Our Reference: 1050P/ConsRespLet/AB

20 November 2019

Reserved Matters Application Associated with Outline Planning Permission P/140/16/OUT-90 Dwellings, Summer Lane, Pagham. ADC Reference: P/70/19/RES

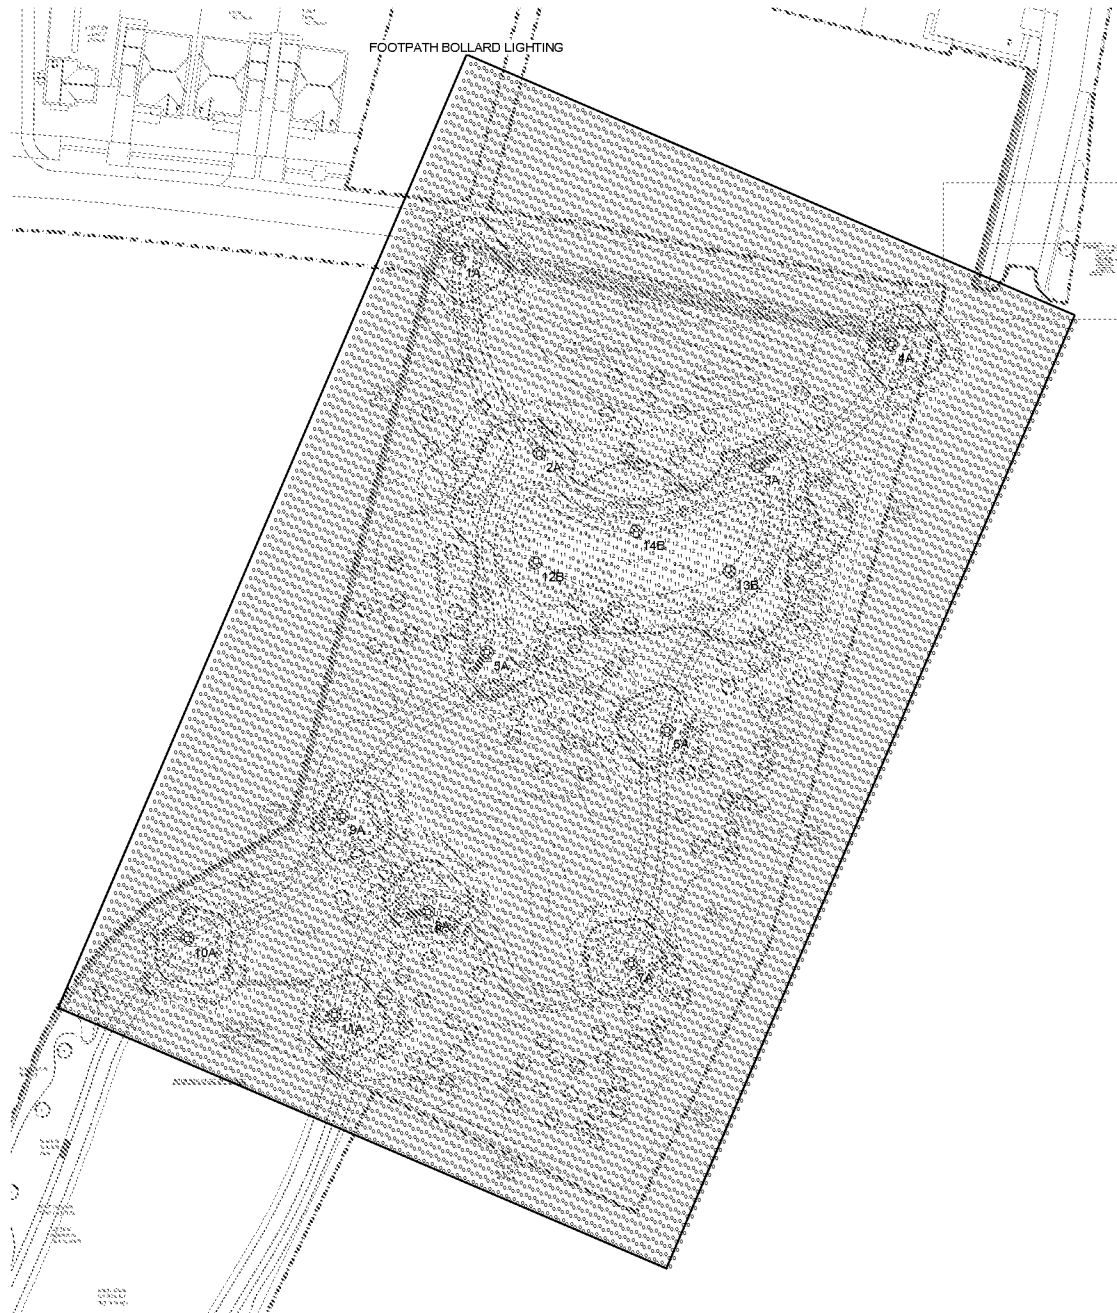
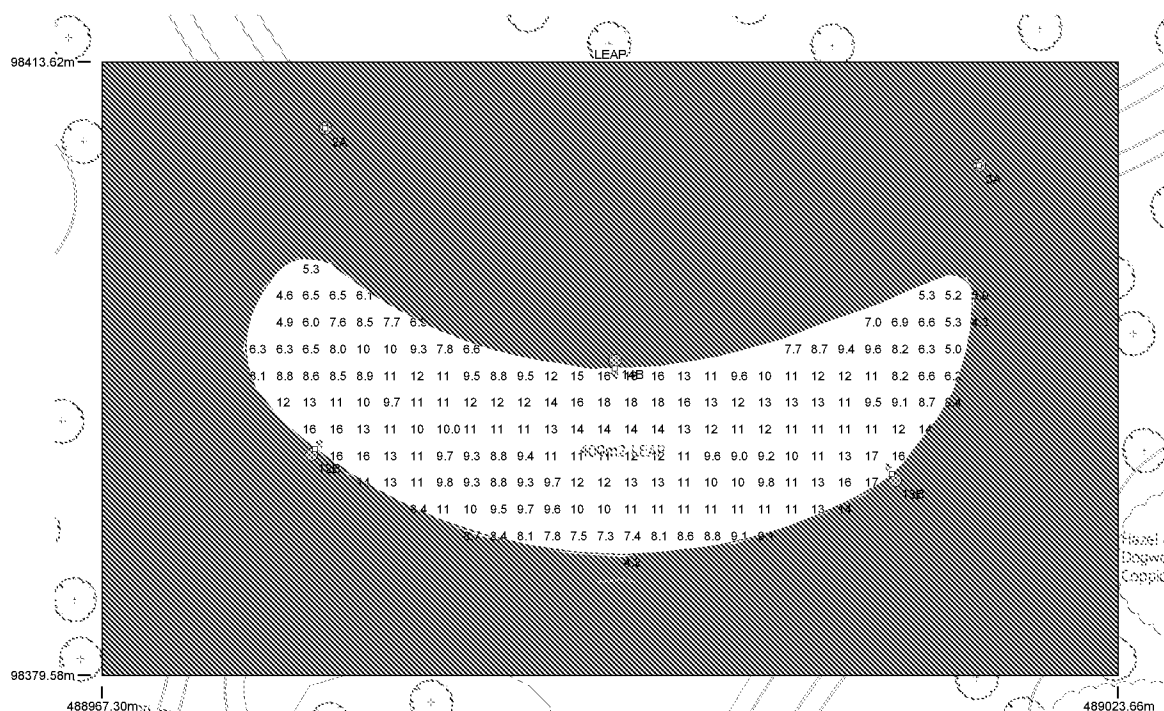
- **ADC EHO-** *Not objecting but recommending conditions re electric vehicle charging, hours of construction, need to consider air quality issues, agreement of lighting details, noise levels, land contamination and agreement of a CEMP*

- **Policing Support Team-** *Submission highlights need for car parking to be visible from an active room, need for defensible space, need for adequate defences, need for secure gates, need to promote surveillance in the land south of Summer Lane and highlighting that lighting must be BS 5489:2013 compliant.*

On the matter of lighting, as reflected in suggested condition 4, it is considered that these requirements have already been effectively addressed within the submitted material for the development site. Indeed, reference should be made to drawings 100046.PRIV.1300.P03 for details. An additional lighting layout has also now been produced for the public open space area– 100090.POS.1301.P01, as requested by the consultee.

This letter is accompanied by a layout plan and strategy for the open space. Any lighting to be installed will meet with all statutory requirements (such as BS 5489:2013) with the relevant certificates and documentation being provided by the approved installer under the necessary conditions of Planning and/ or Building Regulations Approval. The approach will also serve to minimise impact on ecological interests at the site.
